Subject: RE: Letter to Parish Council Re Drainage queries. FP/171/18/PL

I have had drainage advice re the recent drainage documents. The advice is:

Client	MJA CONSULTING CIVIL AND STRUCTURAL ENGINEERS Monarch House, Barton Lane, Abingdon, Oxon, OX14 3NB Tel: 01235 555173 Fax: 01235 523226		
Project	Felpham		
Title	Engineering Layout	Scale 1:200@A1 Checked KTG	Date Mar'18 Drawn JRV
Drawing No.	5782:01	Rev C

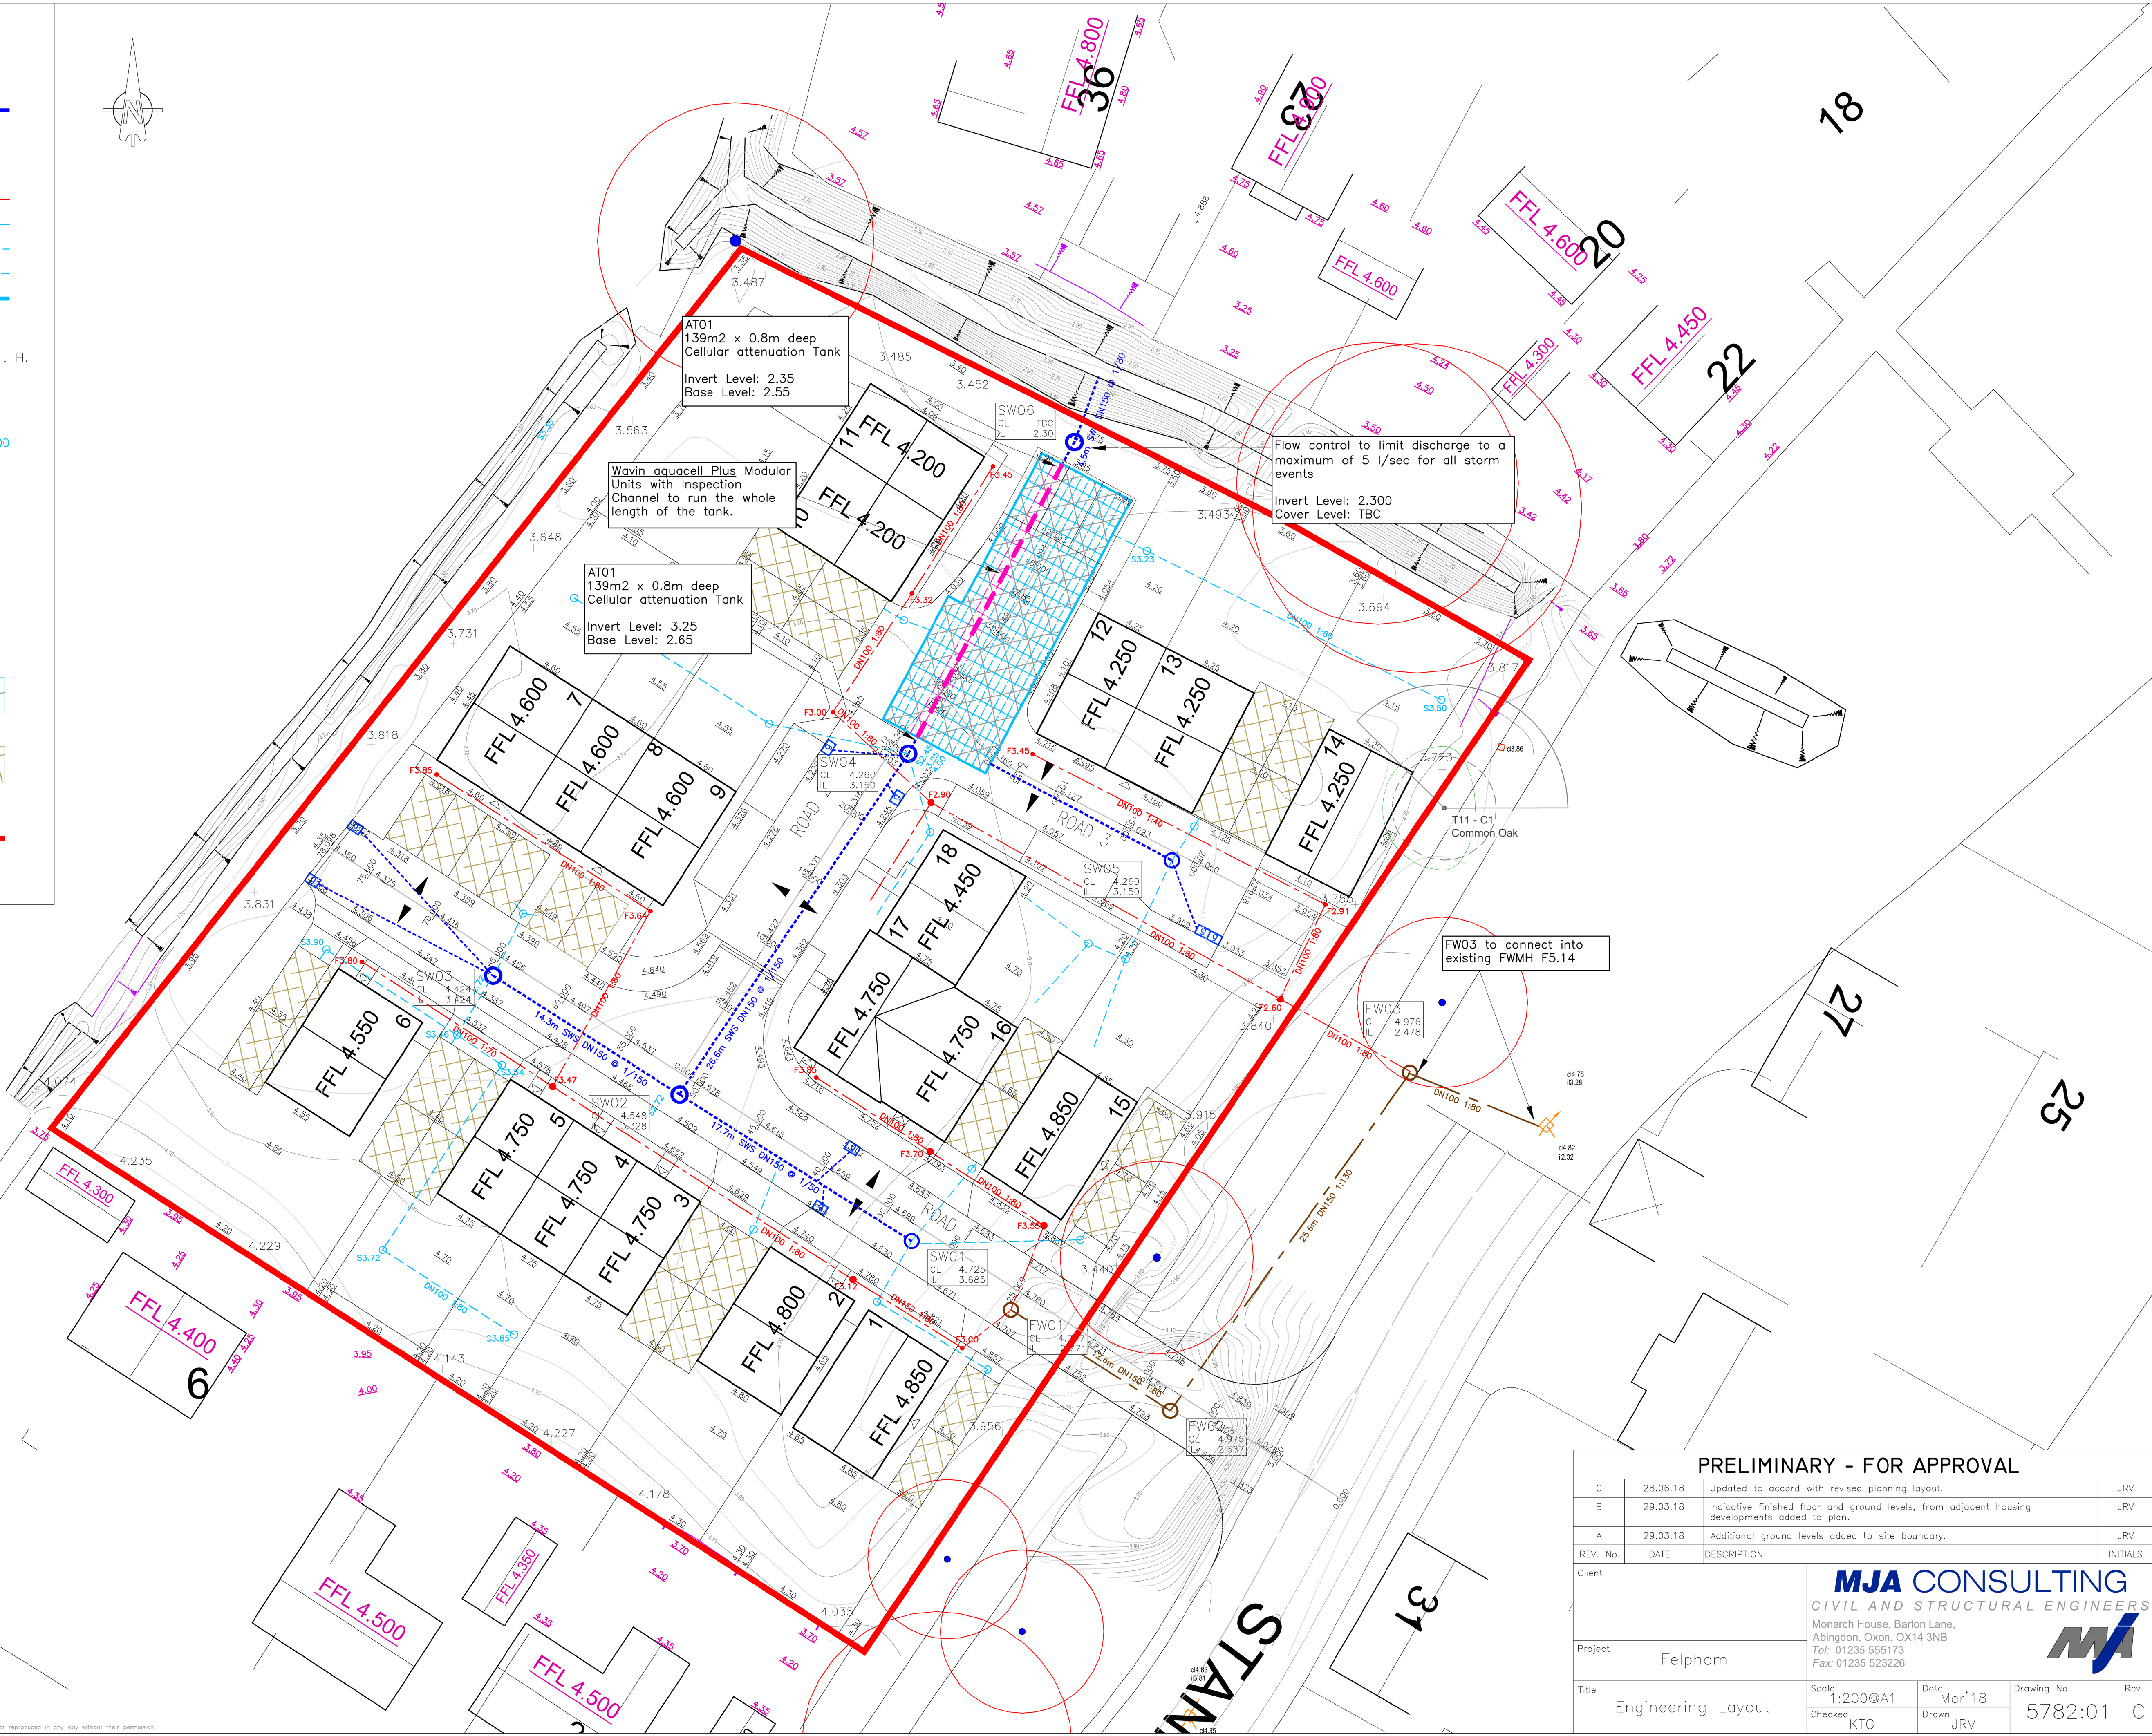
"The letter provided has a mistake within it. All discharge rates should be stated as 2.8l/s. Within the cellular attenuation crates section "5 l/s" is stated. This needs to be corrected, so that no contradictory details are present. 2.8l/s is the correct figure."
